EPC STORMWATER REVIEW COMMENTS IN ORANGE BOXES WITH BLACK TEXT

THE ROCK COMMERCE CENTER SUBDIVISION FILING NO. 1
 EL PASO COUNTY
SITE DEVELOPMENT PLAN
 GRADING PLAN

THE ROCK COMMERCE CENTER SUBDIVISION FILING NO. 1
 EL PASO COUNTY
SITE DEVELOPMENT PLAN
 INITIAL EROSION CONTROL PLAN

THE ROCK COMMERCE CENTER SUBDIVISION FILING NO. 1
EL PASO COUNTY
SITE DEVELOPMENT PLAN
INTERIM EROSION CONTROL PLAN

GRADING PLAN

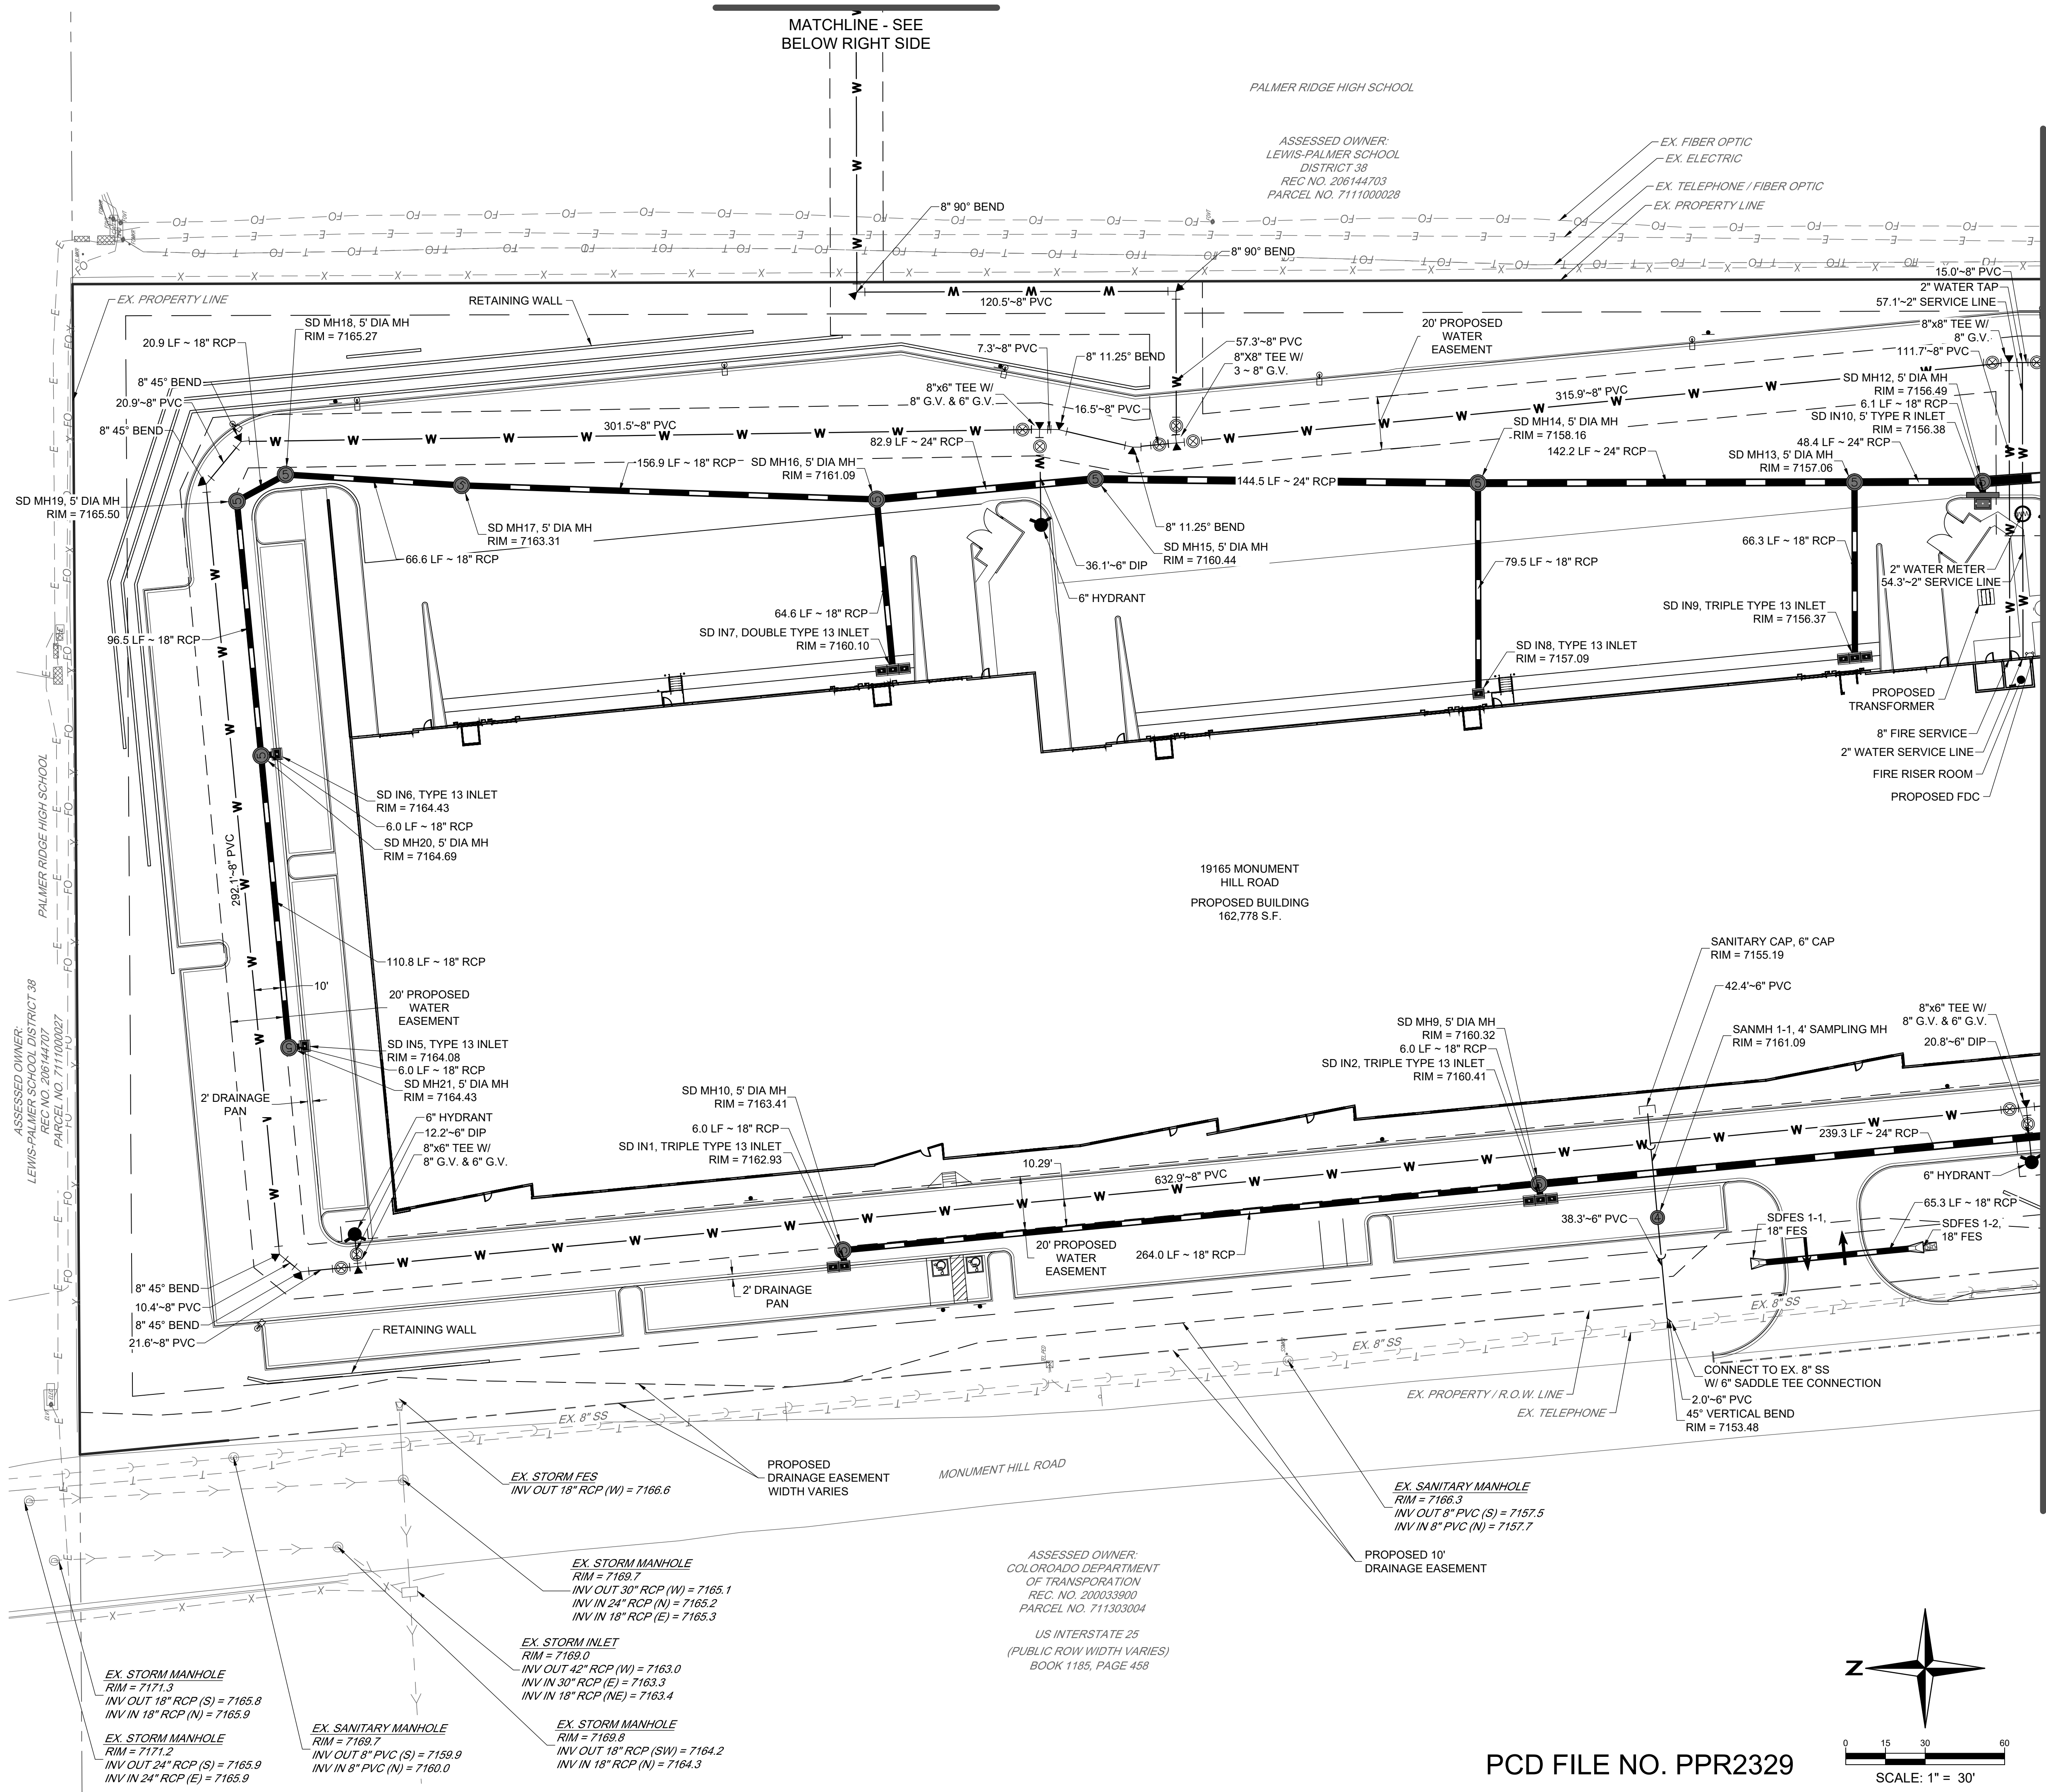
continue limits of construction.
 Show limits of disturbance. If limits are the same label as such

Please provide a cover sheet for the Grading and Erosion Control Plan.
 Please include the GEC Plan signature blocks. See the attached link for signature block document.
<https://planningdevelopment.elpasoco.com/wp-content/uploads/Engineering/EngineeringDocuments/Standard-Signature-Blocks-1.doc>

Include a vicinity map on Cover Sheet
 include GEC Notes (see GEC Checklist Section 3)
 To comply with the SWMP Checklist Item 17f, please add a note stating no batch plants will be utilized onsite.

Minimum width shall be 15' please revise.

Provide slope for access road.

Label if this is riprap. Provide type, thickness, and sizing.
